Office of Water

DARGUES REEF GOLD PROJECT – EXHIBITION OF ENVIRONMENTAL ASSESSMENT

NOW DETAILED ASSESSMENT COMMENTS DARGUES REEF GOLD PROJECT – EXHIBITION OF ENVIRONMENTAL ASSESSMENT

**Figure 6 Modelling Plot Showing Water Levels in the Harvestable-Right Dams**

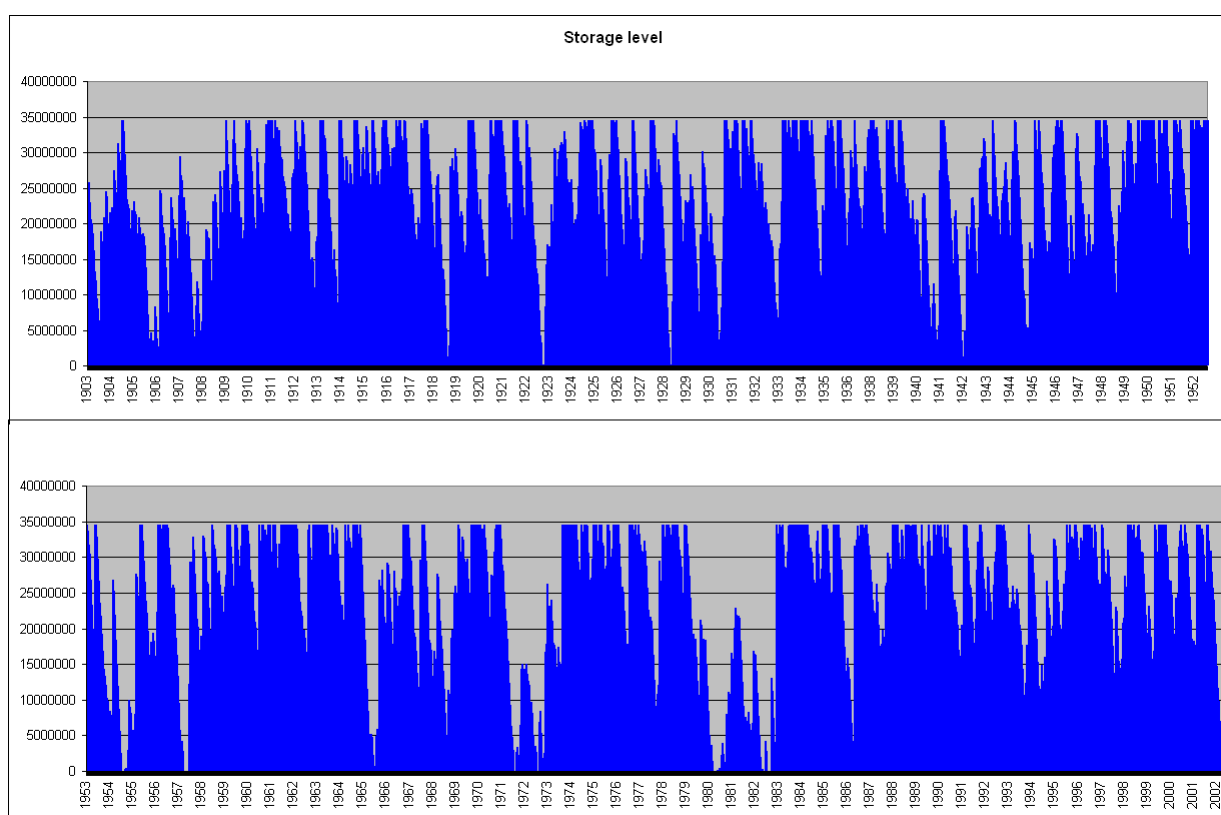
- The model applied to assess the availability of surface water in the harvestable right dams has included 100 years of rainfall data however it has not included data from the last 8 years. This data is considered critical due to the extreme drought conditions.
